Current Zoning: R-17MF(CD) LLWPA (multifamily residential, conditional, Lower Lake Wylie Protected Area)
Proposed Zoning: NS LLWPA (neighborhood services, Lower Lake Wylie Protected Area)

Approximately 1.61 acres located north of Dixie River Road, just west of Shopton Road.

The petition proposes to rezone a vacant parcel to allow for a daycare facility with associated parking and playground area.

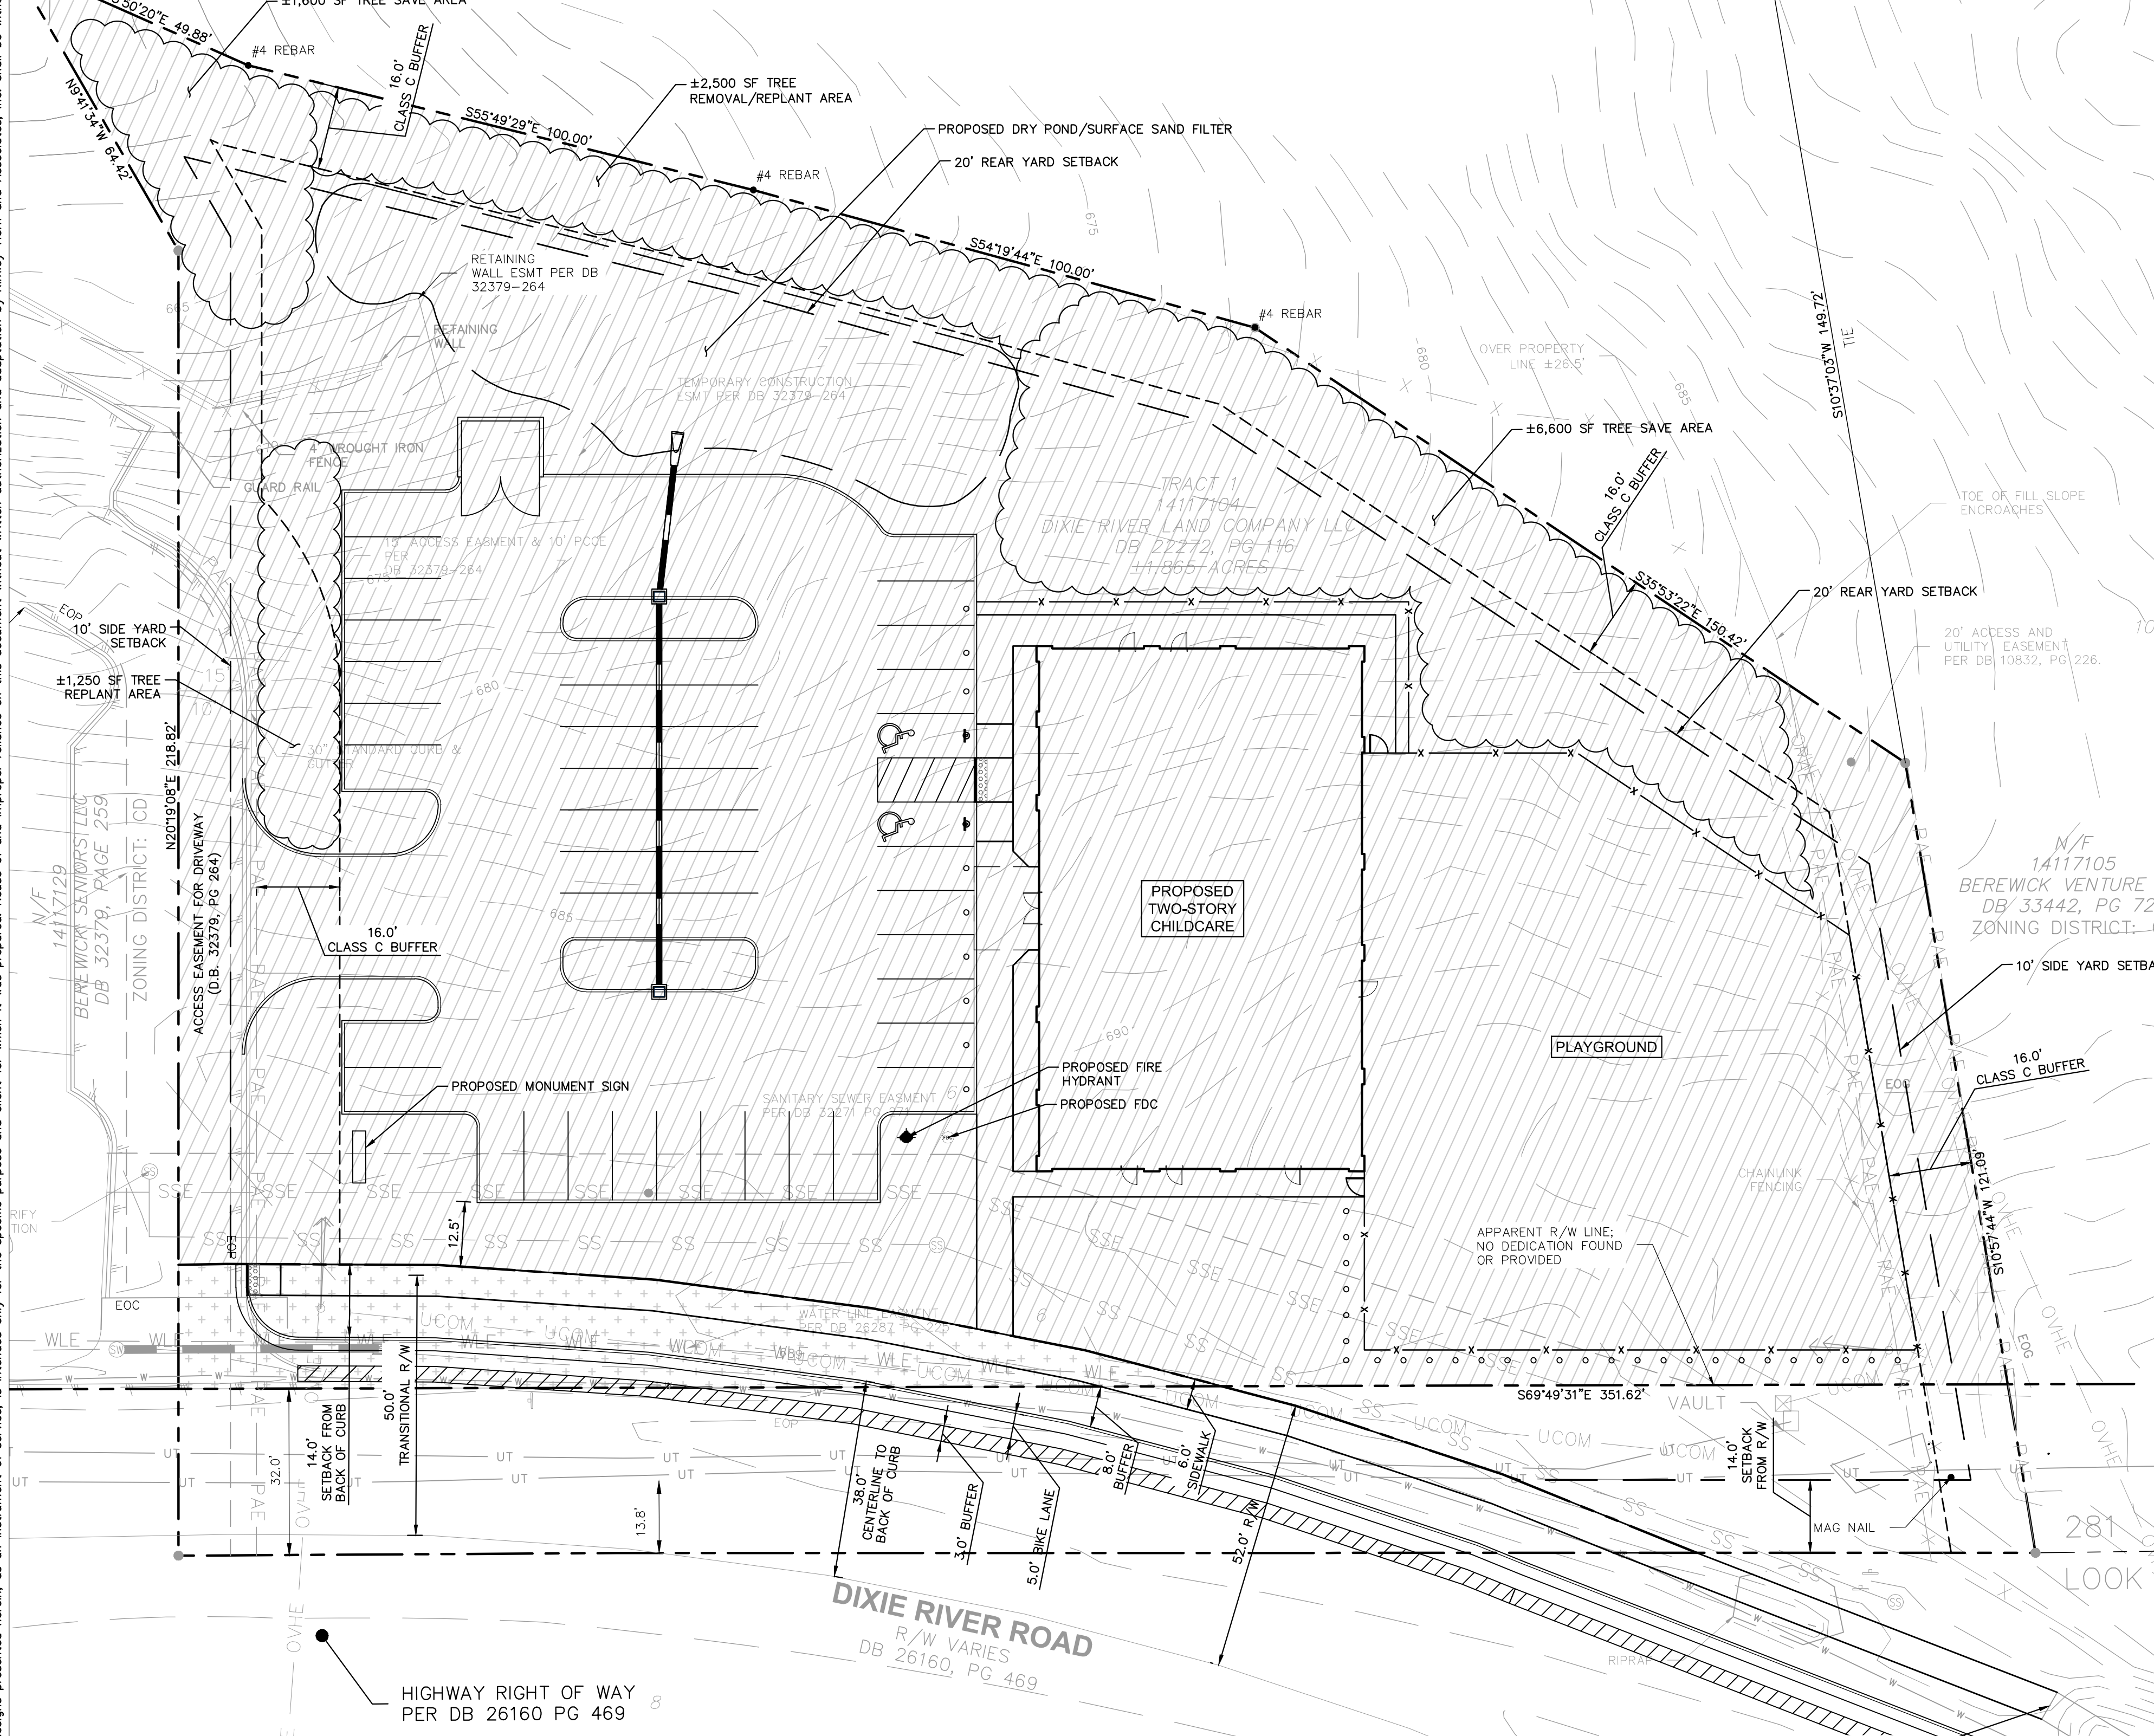
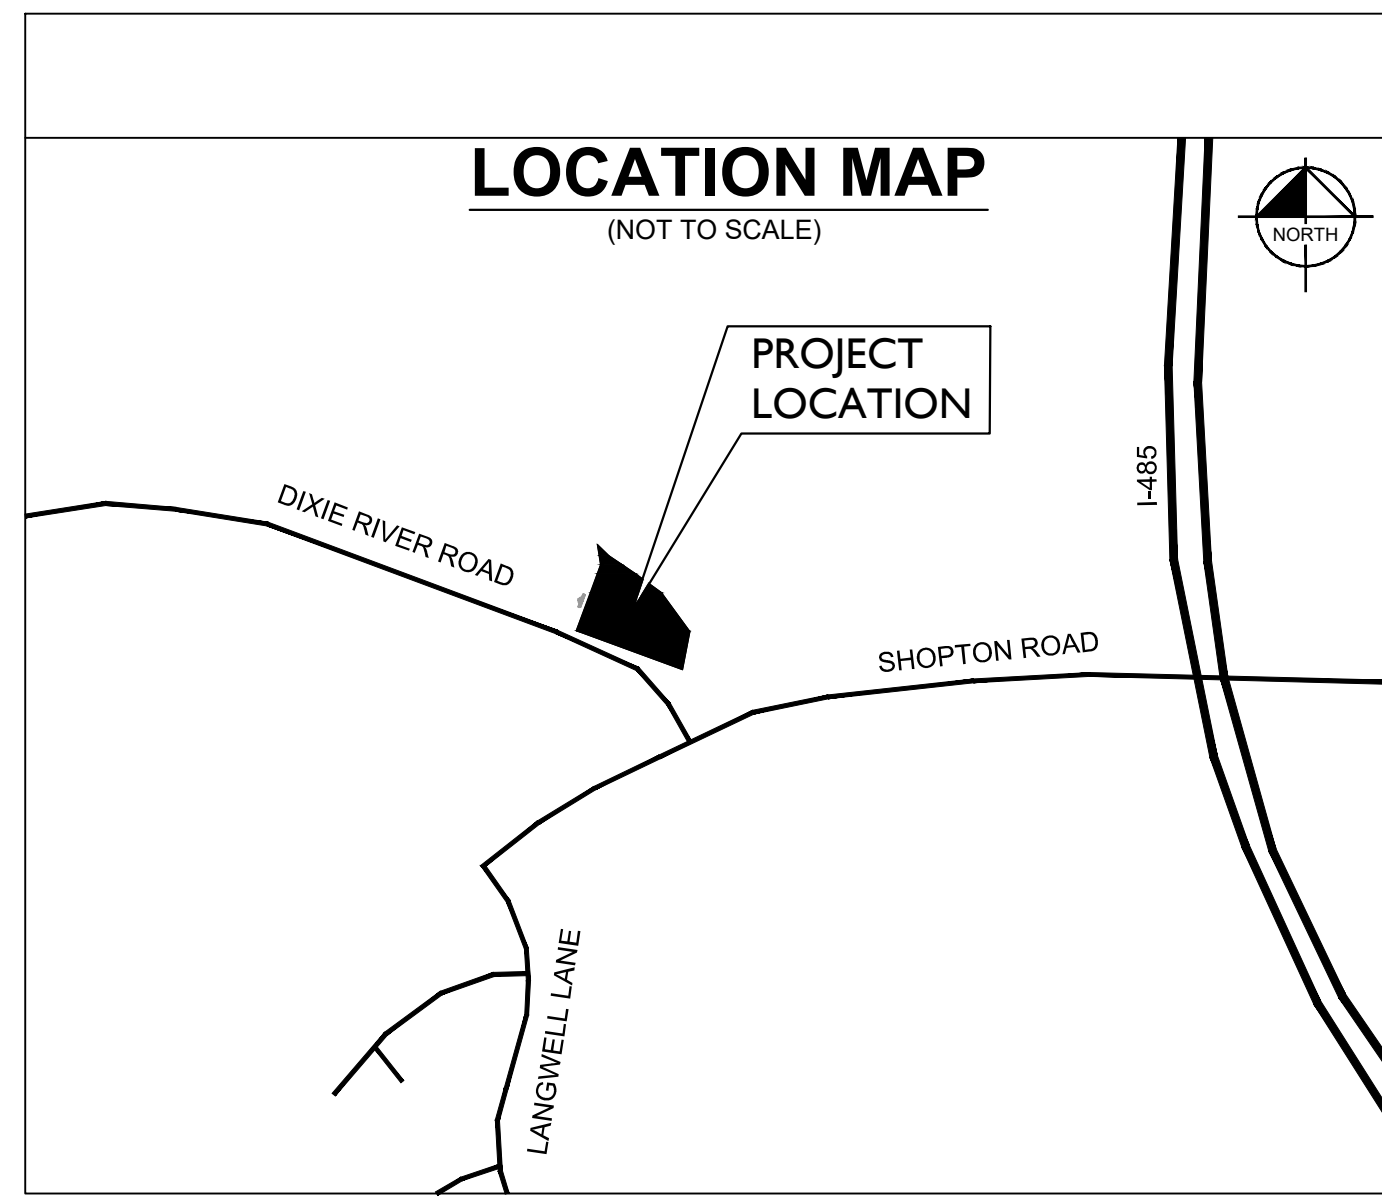
1. Add LLWPA (Lower Lake Wylie Protected Area) to both the existing zoning and proposed zoning on the site plan.
2. Remove notes 3.1 and 3.2 relating to NS uses. They are in conflict with note 3.2.1 and the labeling of the building on the site plan as "proposed two-story childcare".
